**External Envelope:
Glazing, Insulated Render and
Stone Façade Elements**

AERCAP HOUSE METROLINK INTERFACE

Aercap House, St. Stephens Green, Dublin

**Document No:
PR-24-018-BDA-XX-ZZ-RP-Y-0001-C01**

SAINT STEPHEN'S GREEN – CHARLEMONT
RO APPLICATION ALIGNMENT

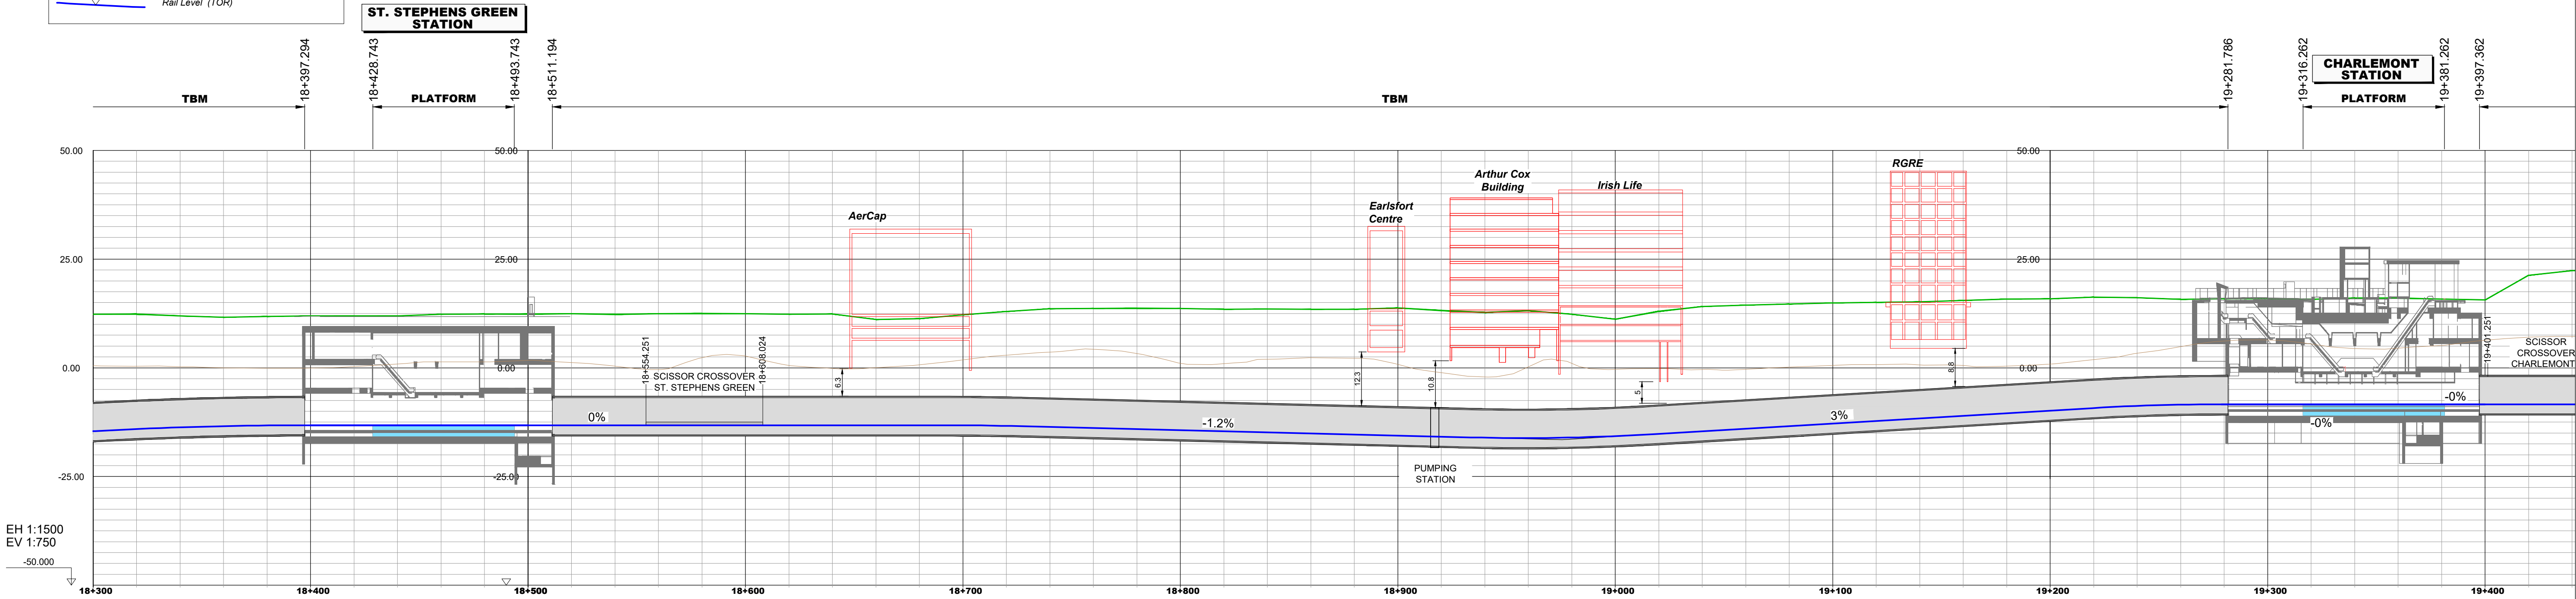
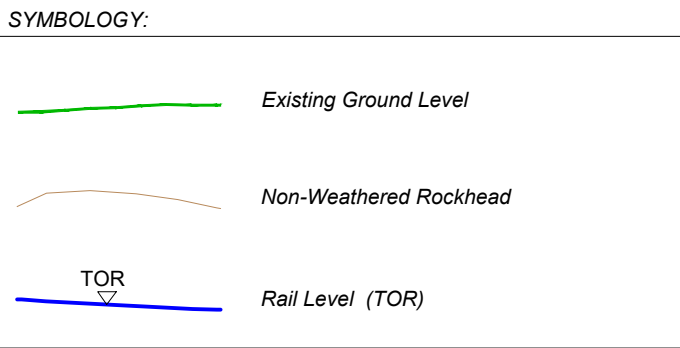
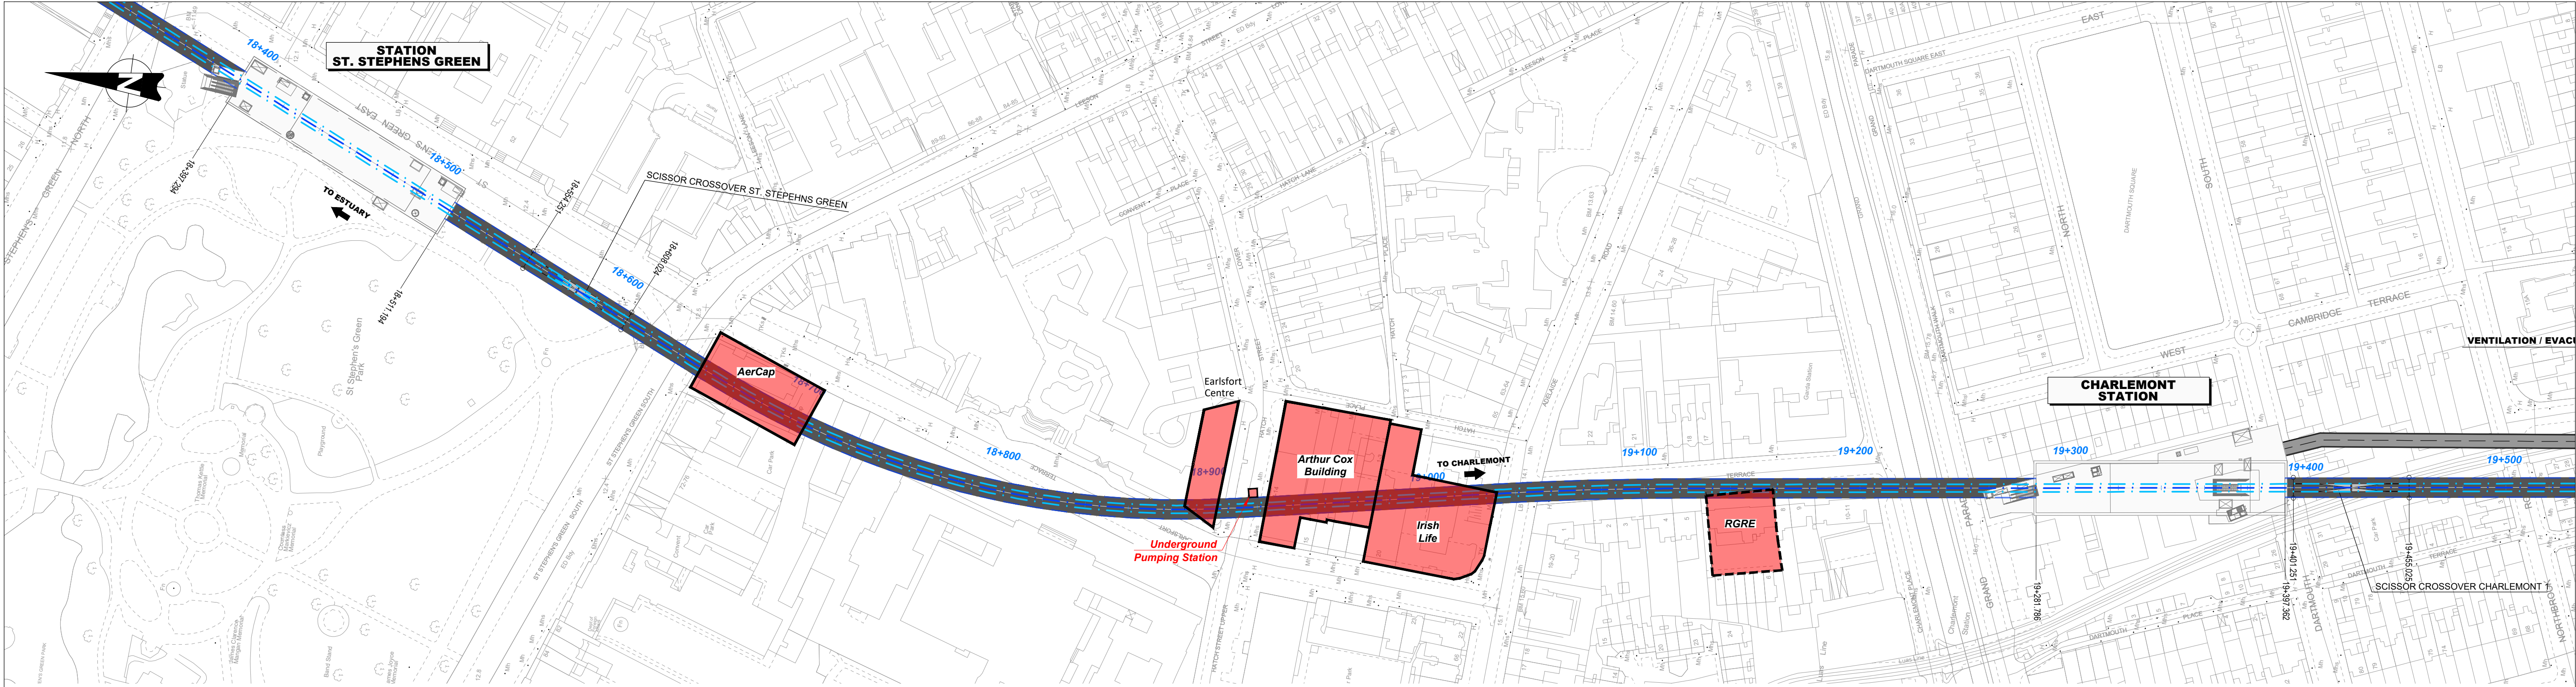
The TII document ML1-JAI-EIA-ROUT_XX-DR-Y-21146 P02 dated 23.02.2024 indicated the settlement of maximum 10mm under Aercap House. With reference to TII Document: 'Addendum to the EIAR – Downward Tunnel Realignment: St Stephen's Green Station to Charlemont Station (P01 06.03.2024)' the ground settlement has dramatically increased. There is no explanation in the document as to why the conditions have worsened to such an extent. The document does not give clarity on the settlement gradient to be expected at Aercap House. There is no Phase 3 assessment and apparently no review of how the particular facades on Aercap House will perform. As a result, we raise the following concerns:

- 1) An updated contour map indicating the predicted settlement should be provided.
- 2) The latest information from TII indicates maximum settlement of 22mm under Aercap House. This figure, which is far higher than previously advised, has the possibility of causing damage depending on the settlement contours.

MetroLink has assessed the predicted "Settlement" and presents its findings on drawing no. ML1-JAI- EIA-ROUT-XX-DR-Y-21146 rev P02. This drawing indicates MetroLink will be causing a 10mm settlement directly under the location of our client's building which is unacceptable. We have not received an update of this drawing.

However, the new document 'Addendum to the EIAR – Downward Tunnel Realignment: St Stephen's Green Station to Charlemont Station (P01 06.03.2024)' indicates a revised settlement of maximum 22.14mm. Settlements of this magnitude cannot be accommodated by the building's facades. Such settlement, particularly if introducing differential settlement between columns, will cause damage.
